**KIRKLEES METROPOLITAN COUNCIL
INVESTMENT & REGENERATION SERVICE**

DELEGATED DECISION TO DETERMINE PLANNING APPLICATIONS

Reference No:	2026/62/90022/W
Site Address:	2, Co-op Lane, Holmbridge, Holmfirth, HD9 2ND
Description:	Erection of first floor Juliet balcony (within a Conservation Area)
Recommending Officer:	Joanna Rednall

DECISION – REFUSED

Section 1
1 : 50

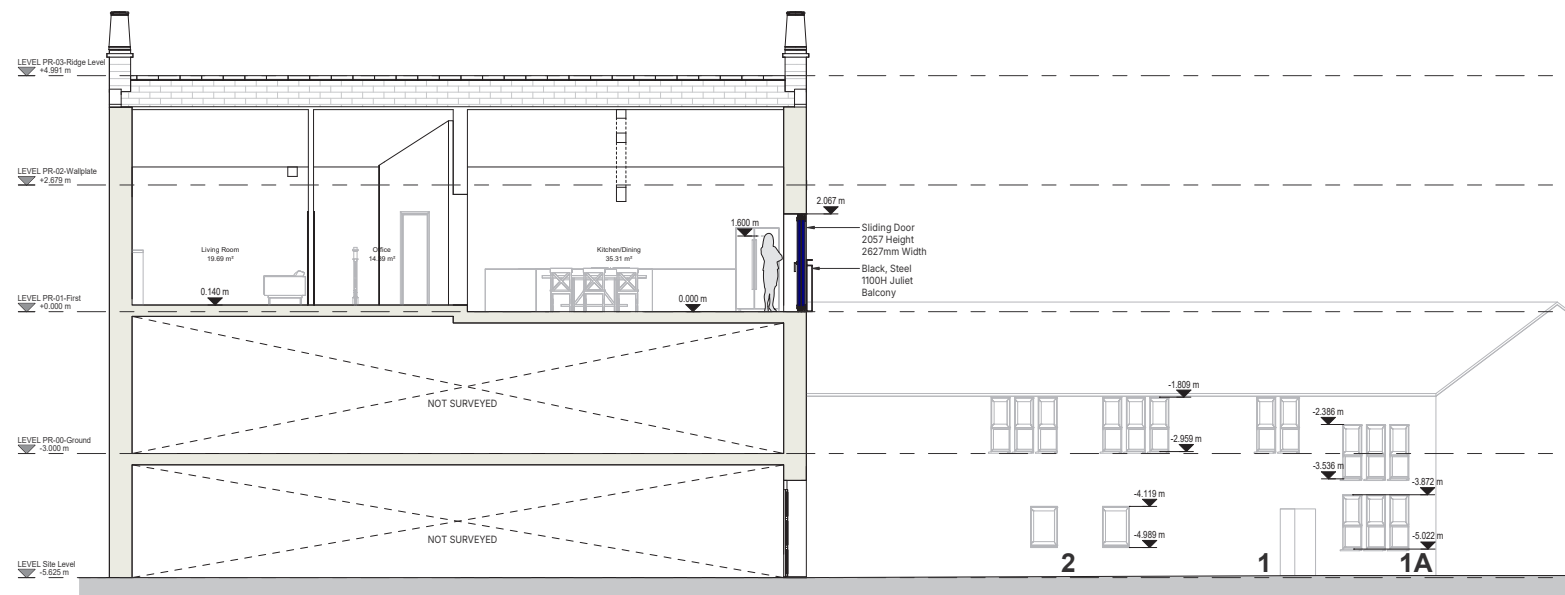
The SPD acknowledges that separation distances should be considered alongside site-specific factors, including the character of the area, local context, and topography. In this case, there is a notable difference in land levels between the application site and No.1 Water Street. The first-floor windows of No.1 are elevated approximately 2.9m above external ground level, while the Juliet balcony sits at an approximate height of 5.5m.

However, officers consider that the information submitted does not sufficiently demonstrate that the level difference mitigates overlooking to an acceptable degree. The elevated position of the Juliet balcony enables clear and direct views into the windows of No.1 Water Street, particularly those at first-floor level serving bedrooms. Given the relatively short separation distances, the relationship results in an unacceptable loss of privacy for occupants.

In addition, the ~2.9m difference in land levels is not considered sufficient to overcome this harm. Instead, the elevated vantage point allows users of the Juliet balcony to look down into the neighbouring windows, resulting in a harmful perception of overlooking for occupants of No.1. Whilst some of the windows are at oblique angles and varying heights in relation to the development the nature of the proposal being to serve a balcony would mean an increased usage and has the potential for a greater degree of overlooking to arise to occupiers of no.1 and no.2.

First Floor Plan
1 : 50

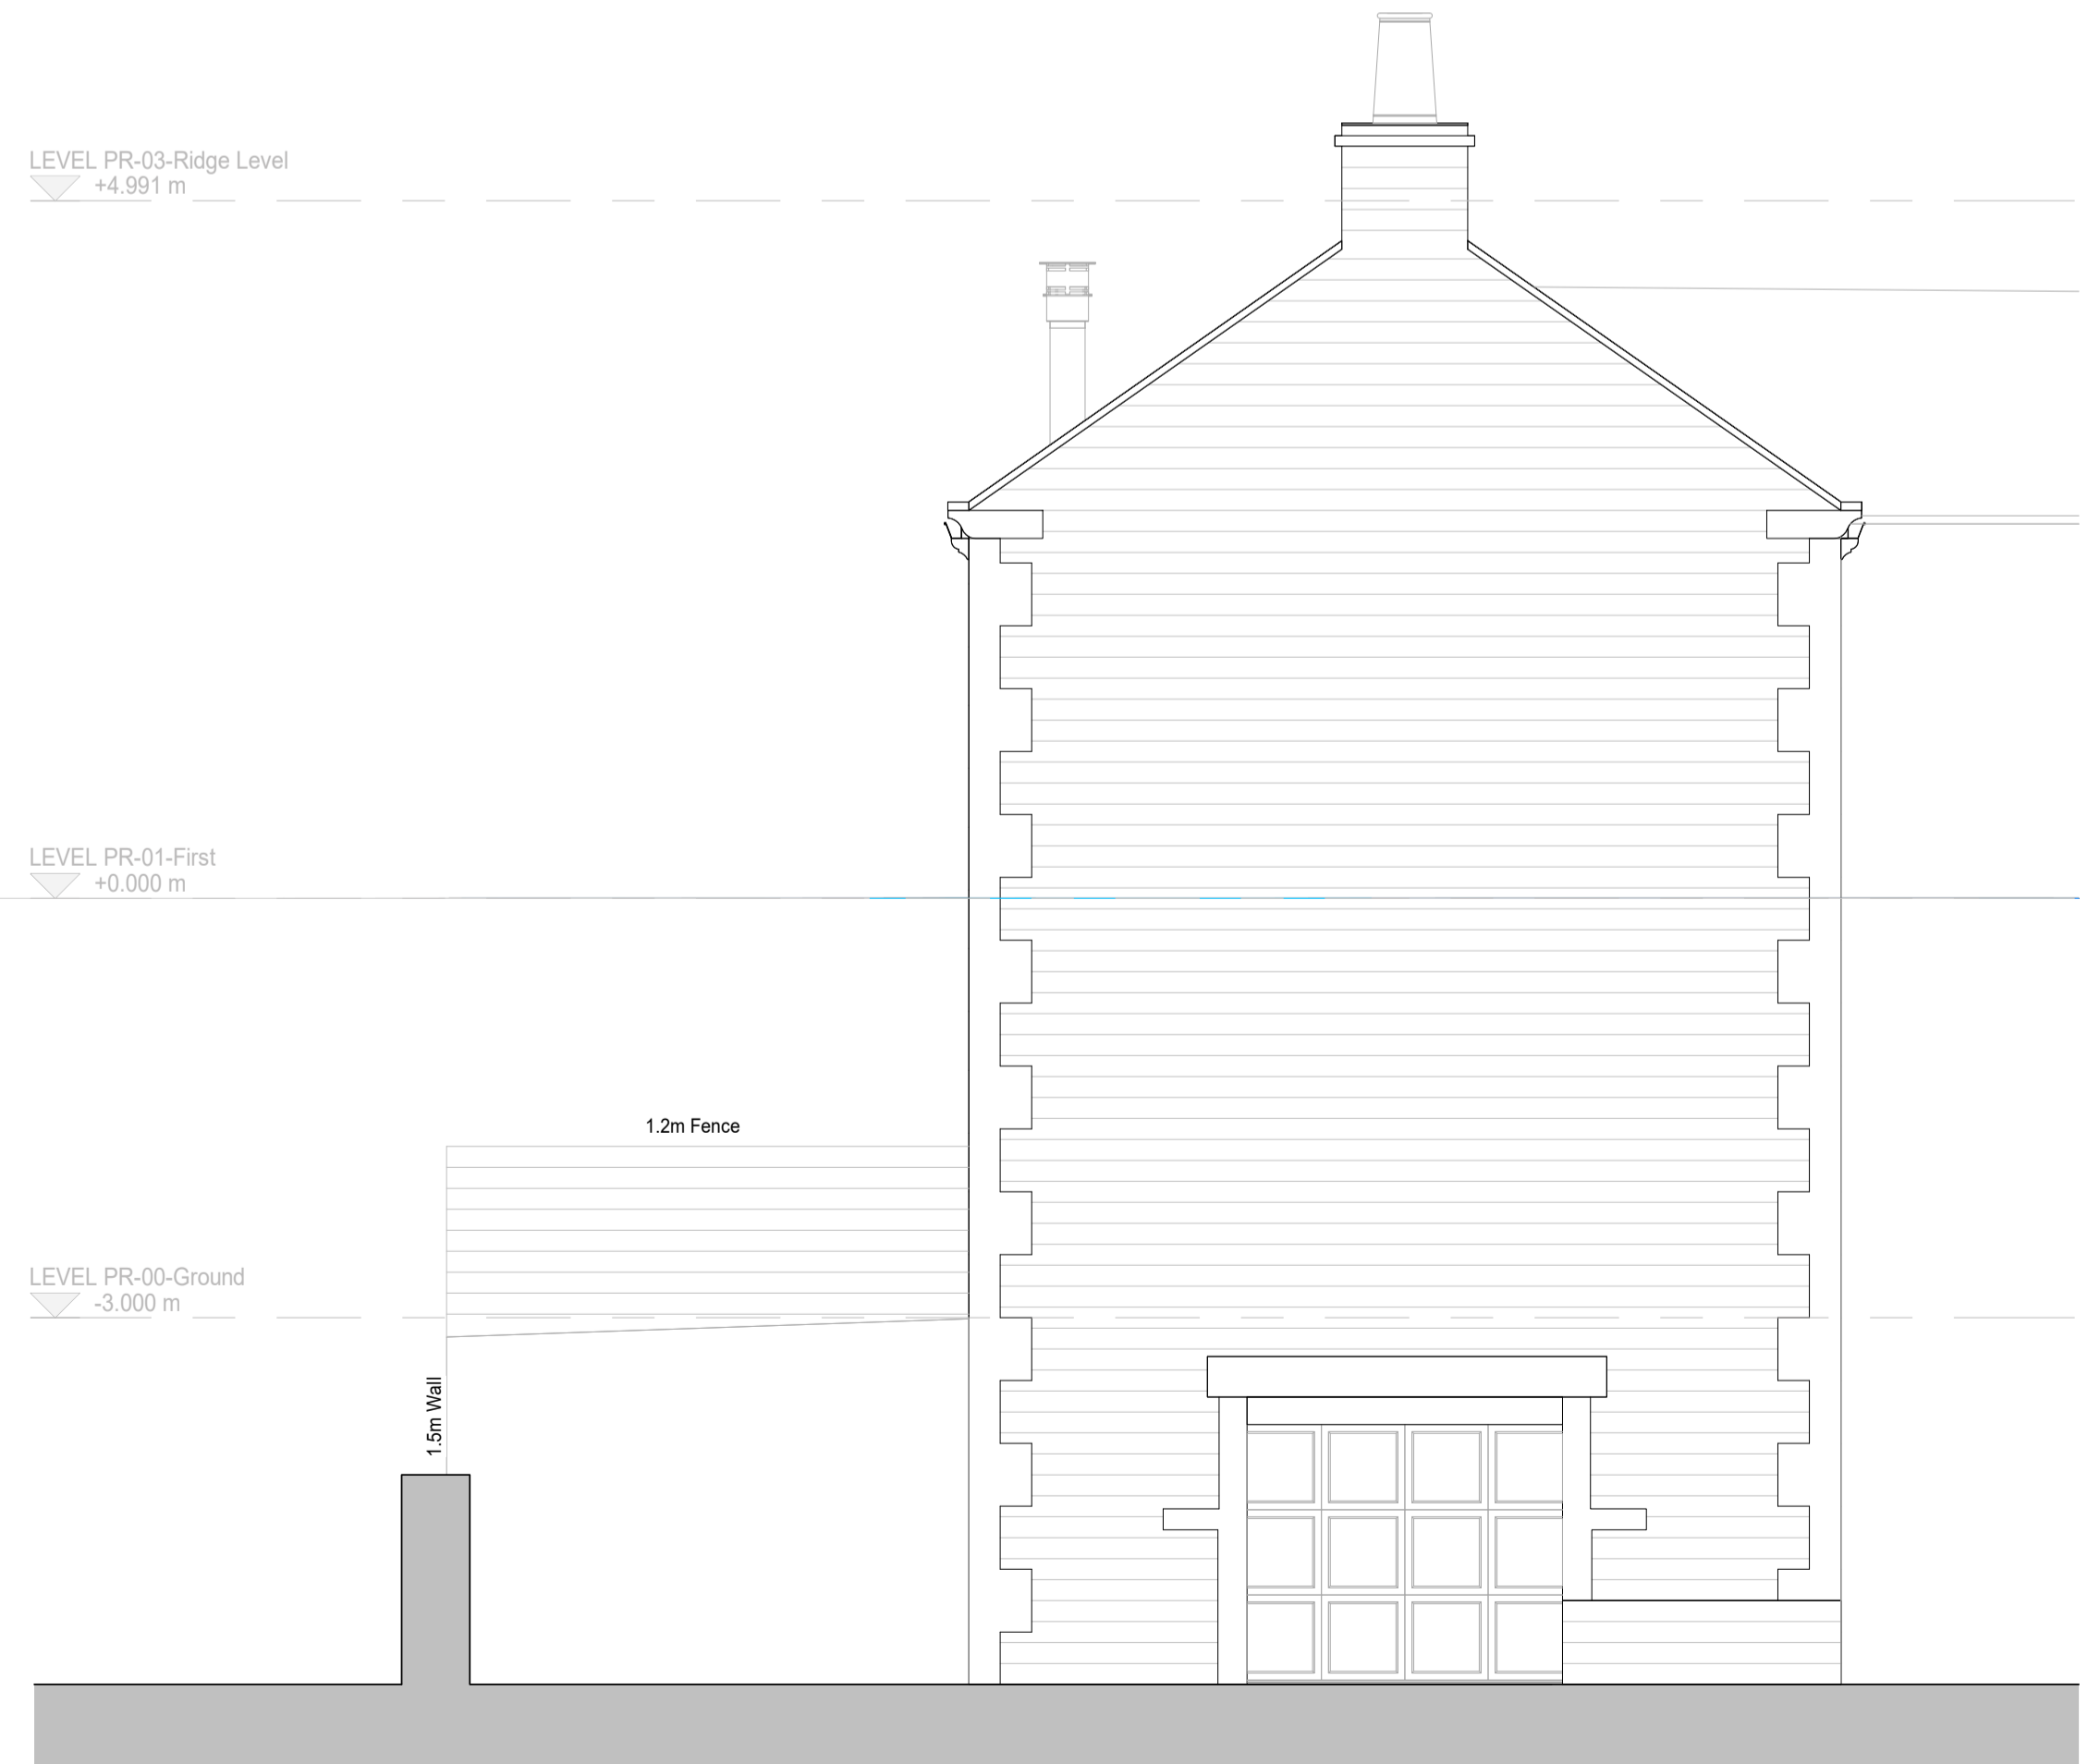
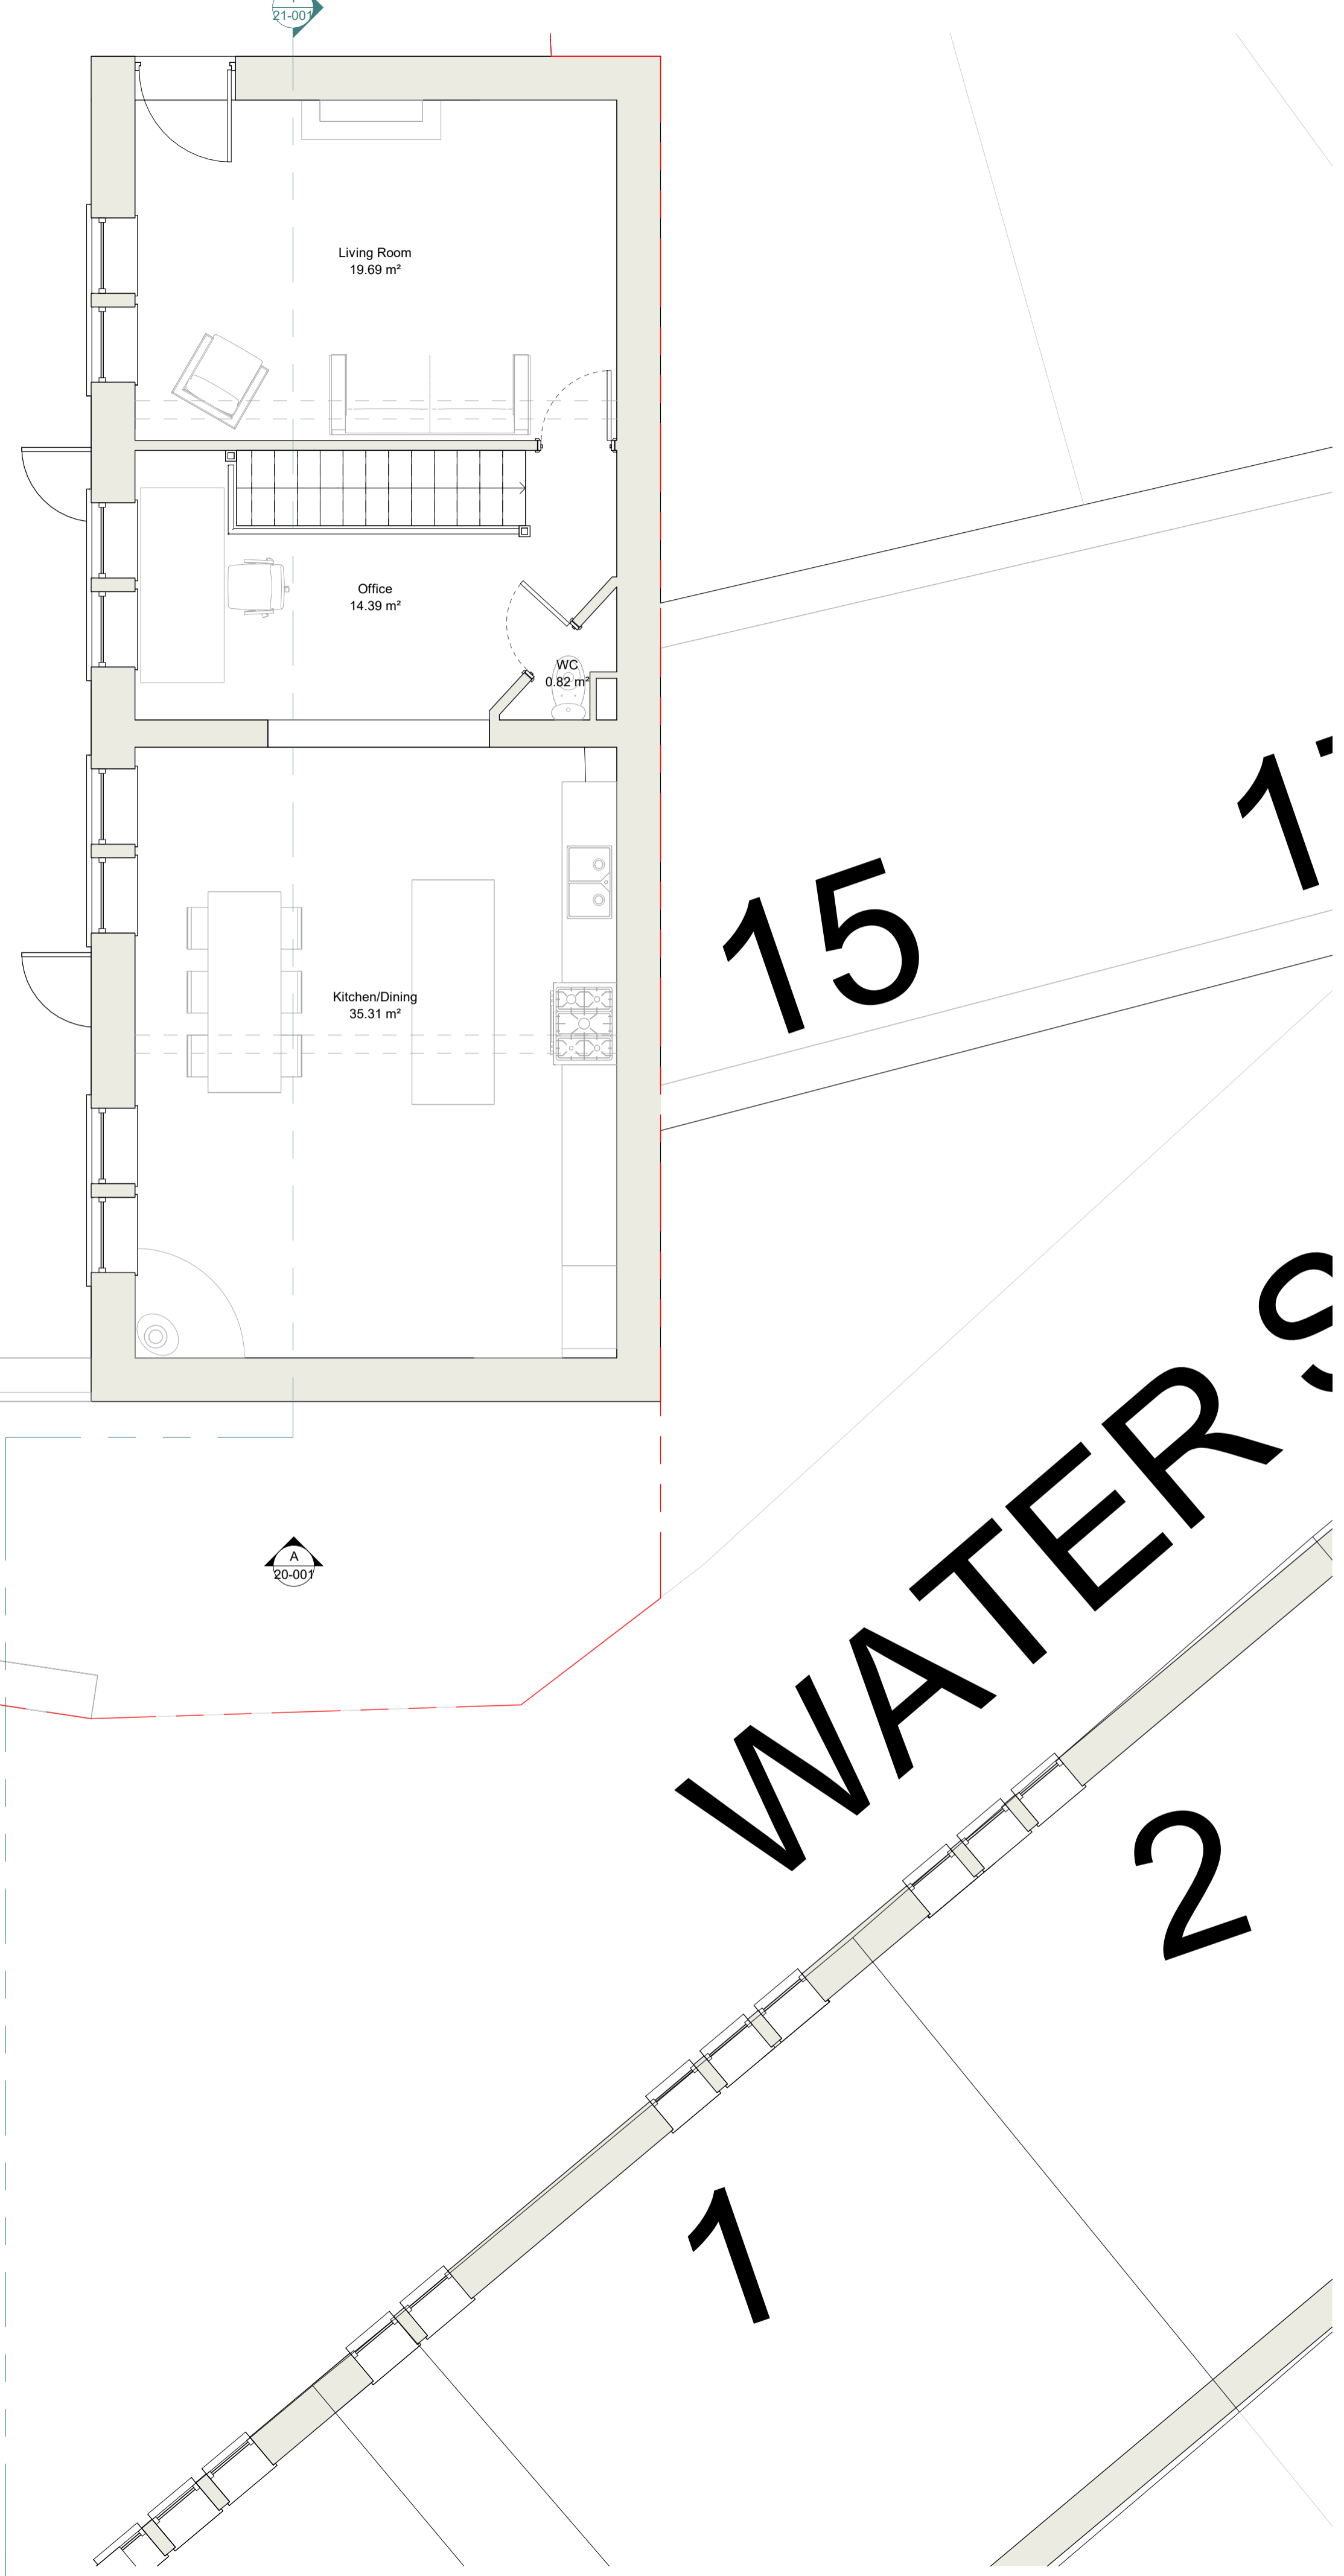
In this case, the benefits of the development are limited to the provision of improved natural light to the occupants of 2 Co-op Lane. The submitted floor plans demonstrate that the kitchen/dining room served by the Juliet balcony is already well served by four openings on the front elevation. As such, officers afford limited weight to an argument that the development is necessary to secure the building's optimum viable use, given that the additional opening serves an already adequately lit habitable space. These benefits are therefore private in nature and relate solely to the amenity of the occupants. Consequently, officers consider that no public benefits arise from the development that outweigh the identified less than substantial harm to the Holmfirth Conservation Area.

A submitted floor plan illustrates the separation distances between the Juliet balcony and neighbouring windows at Nos. 1 and 2 Water Street. This indicates that the development achieves a minimum separation distance of approximately 7.9m to 8.3m, increasing to a maximum of 12.9m to more offset windows. These distances fall significantly below the standards set out in the Council's Extensions and Alterations Supplementary Planning Document, which recommends a minimum separation distance of 21m between windows serving habitable rooms. Where developments fail to meet this standard, robust justification is required.

The Juliet balcony serves a kitchen/dining space. Based on available floor plans, the directly opposing windows at No.1 Water Street serve a ground floor living/dining room and two first-floor bedrooms. These are all habitable rooms, with at least one of the first-floor bedrooms relying on the front elevation windows as its primary source of outlook.
